from: [REDACTED]
 Sent: 11 November 2010 11:21
 To: Janice Chapman
 Subject: Re: AW/227/10/T 1 THE FAIRWAY BOGNOR REGIS WEST SUSSEX PO21 4EL
 Attachments: pastedGraphic.pdf, ATT340850.htm

From: Ian Brewster
Sent: 08 November 2010 16:57
To: Janice Chapman
Subject: AW/227/10/T 1 THE FAIRWAY BOGNOR REGIS WEST SUSSEX PO21 4EL

I have inspected the above development site and refer to the tree survey provided by Artotech reference UA/001/TS1.

APPENDIX 1
 TREE SURVEY PLAN (Existing)
 Indicating tree location on site.

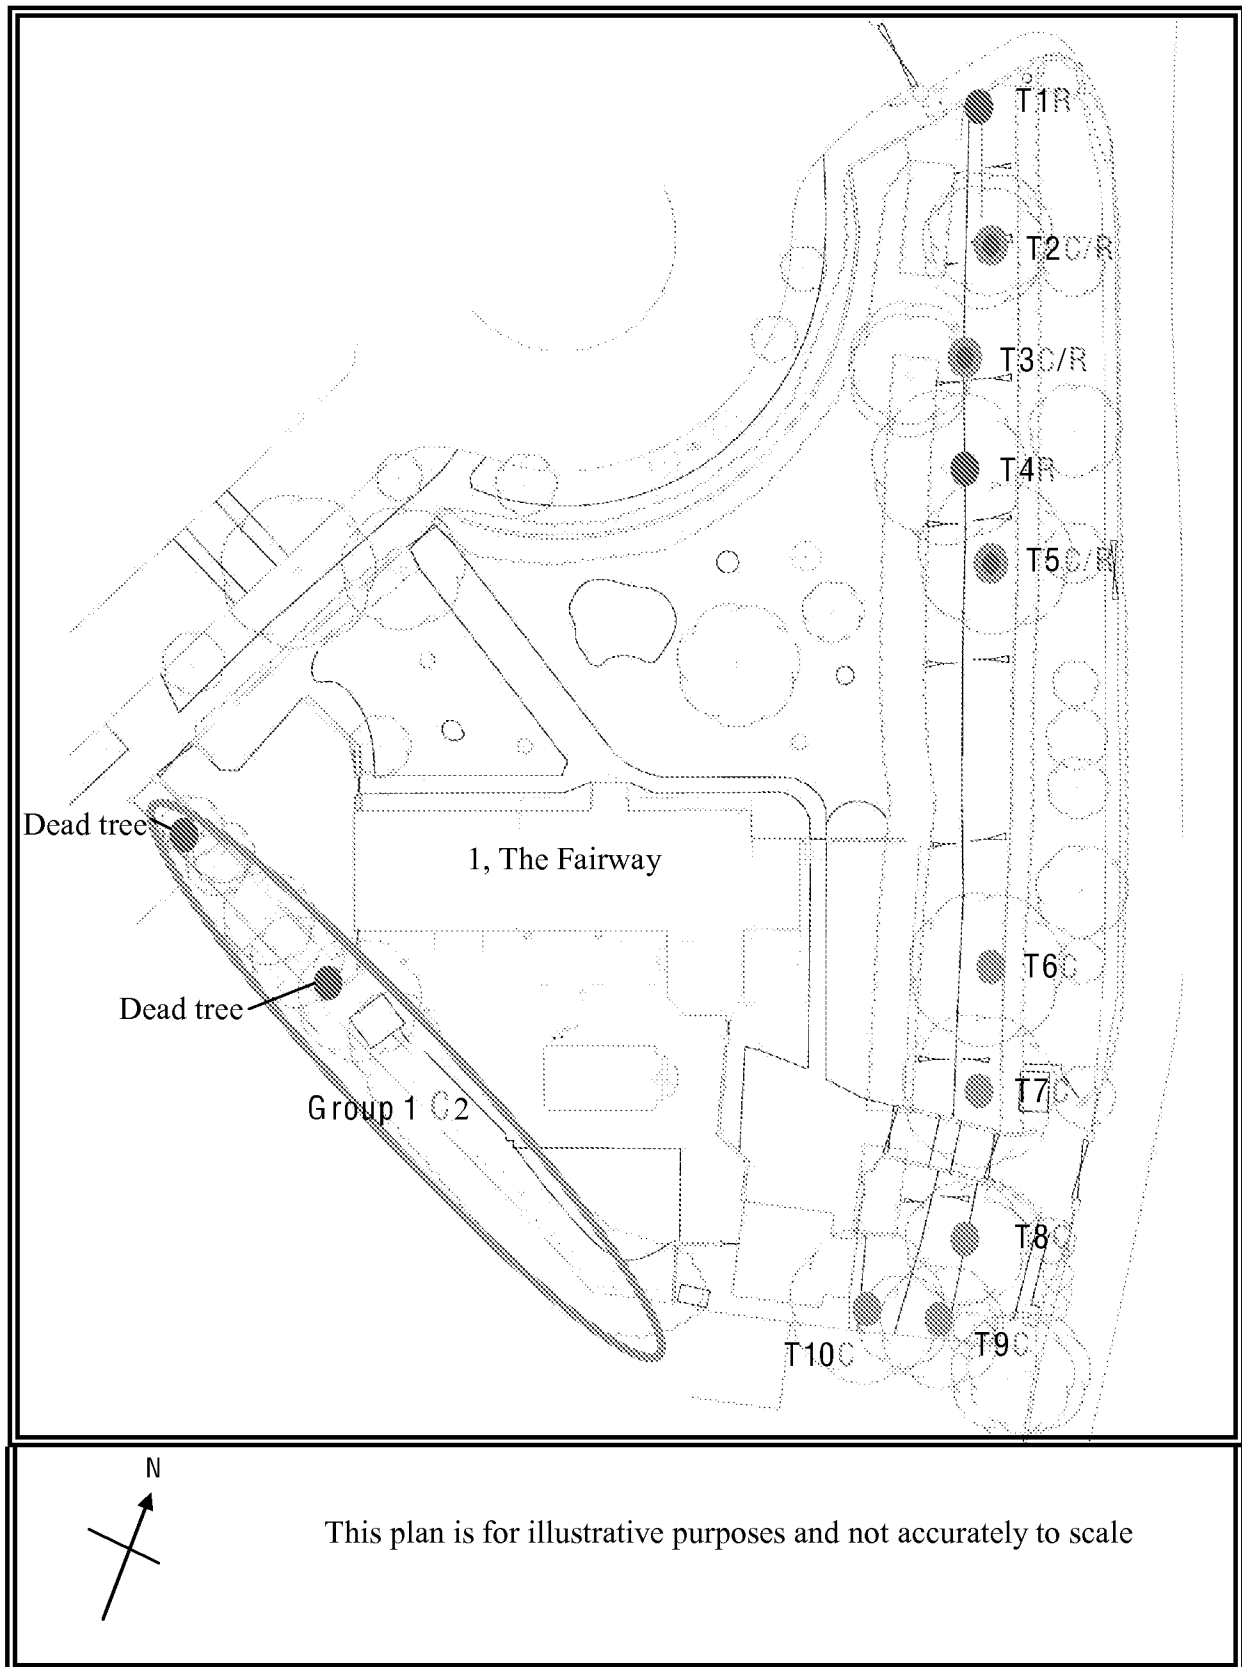
I can confirm that T1 is dying and T2, T3, T4, T5 (to the north east and both sides of the ditch) and T9 (marked as T8 but which is the farthest tree to the south east of the site) are not worthy of retention due to their poor condition and health as indicated in the tree survey.

However T6, T7, T8, T10 are in good condition and their retention is desirable. The inspected trees are Sycamore and have been lopped approximately 15 years ago with visible dead stubs of around 150mm diameters which are in a state of decay. Strong growths have occurred around these points to provide a stable union. As the stubs decay these points will need to be inspected if the growths become too large to remain safely attached.

Part of the architect design is to culvert the southern part of the ditch which will affect all trees to the south of T5. This will particularly affect T6 and T7 which are located low on the ditch side. T7 has large wounds near to the tree base and if these and the lower stems of other trees are covered with soil as part of infill this will create anaerobic conditions, bark death and basal decay. Underlying roots emanating from these trees beneath the ditch, which extend outwards within the Root Protection Area may also be affected. It is recommended that the ditch remain open rather than a culvert. However if the architect can design an acceptable method which will allow for gaseous exchange of affected roots and bark, then we should consider whether this is appropriate.

We will re-submit showing trees T1 - T5 & T9 to be removed, which I trust is acceptable to ADC at officer level.
